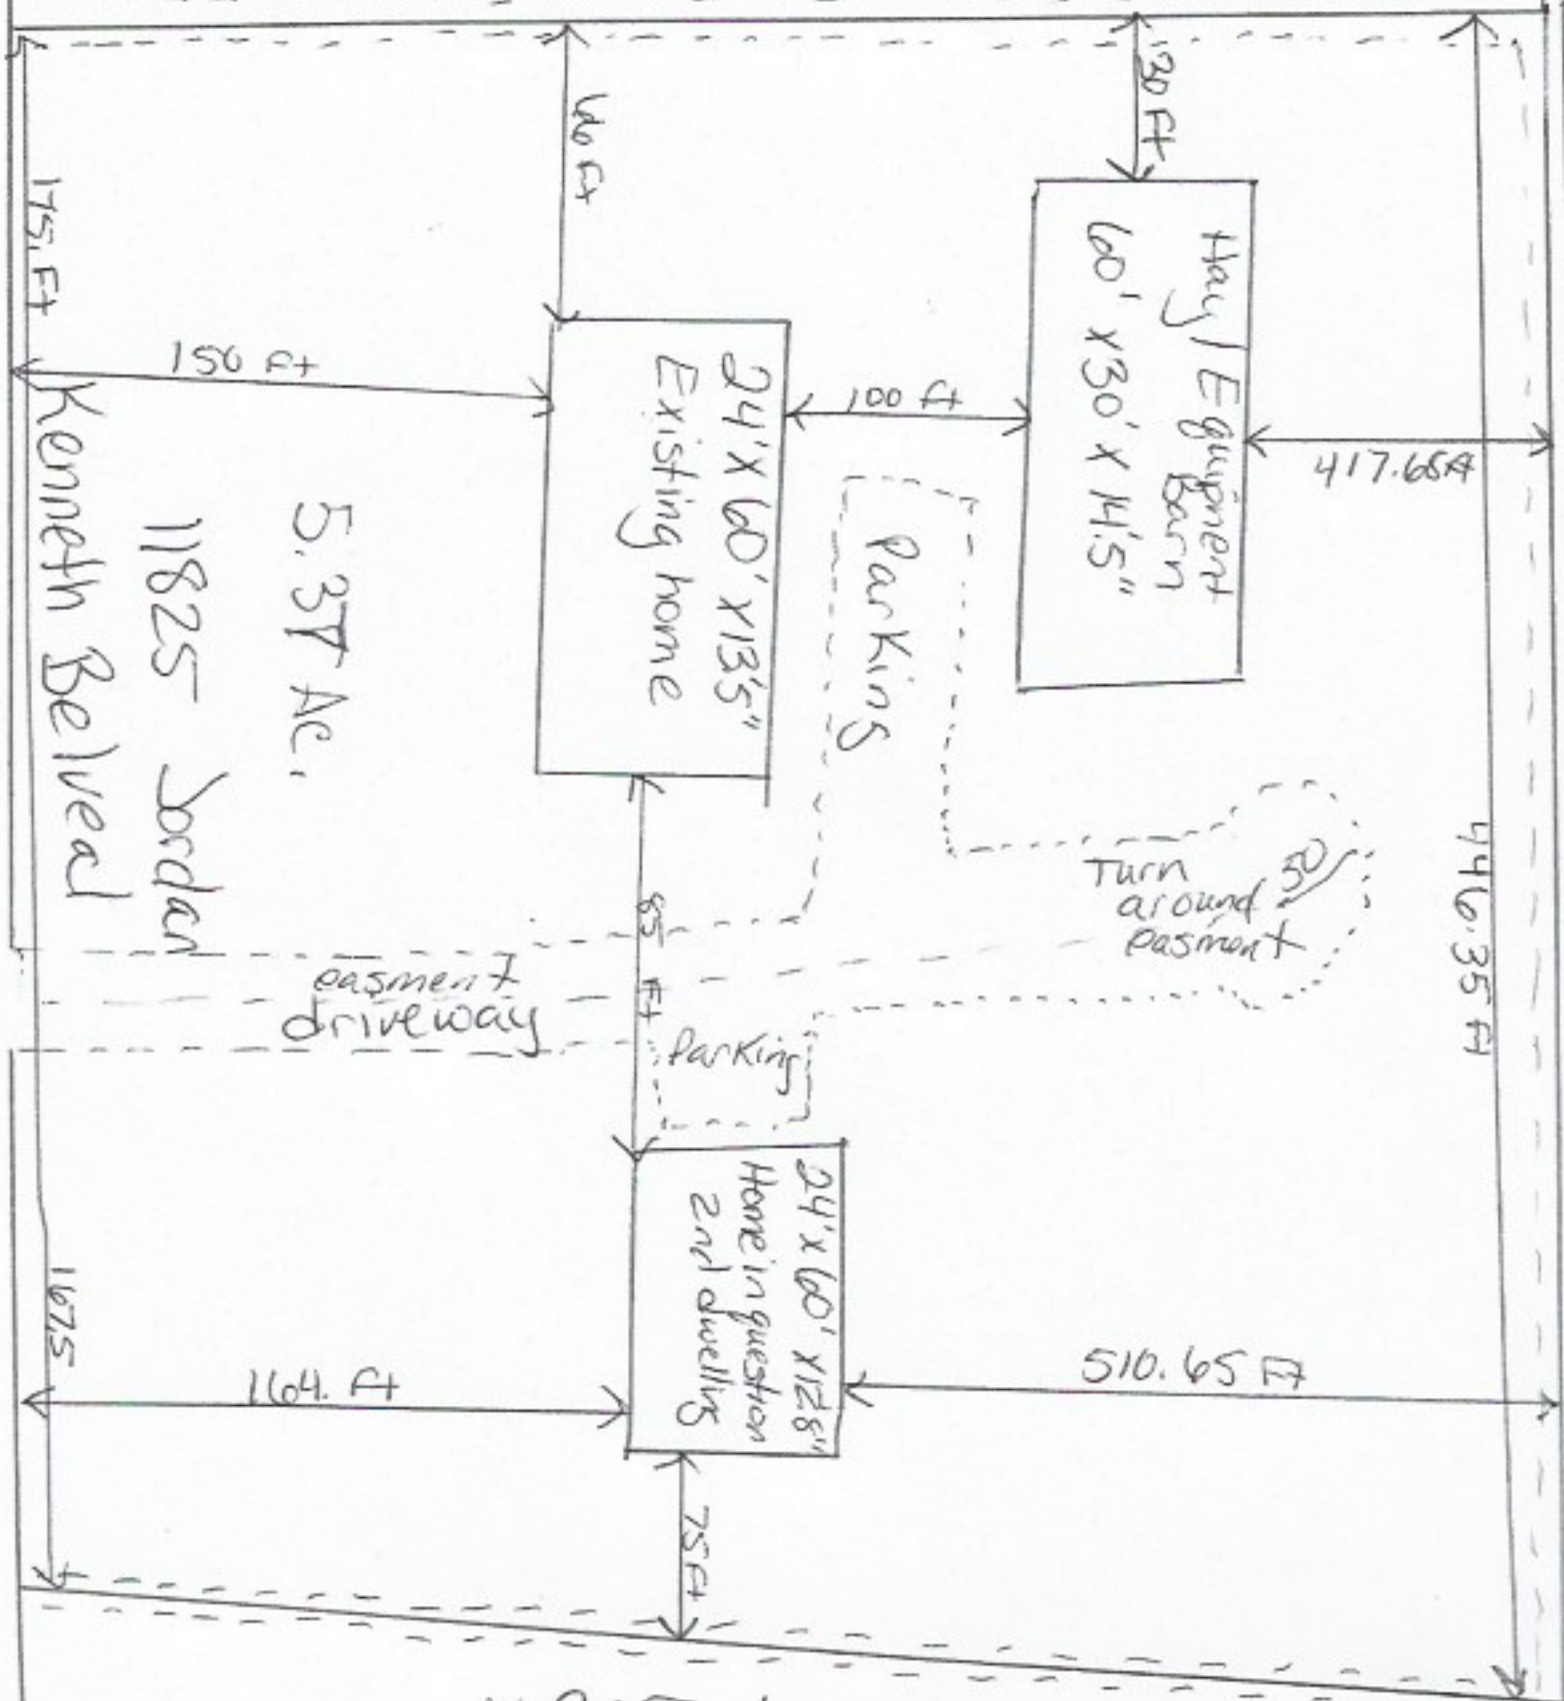
Show all easements from the Plat on this drawing.

10' around the sides and rear of the property plus a turnaround easement through the middle of the property.
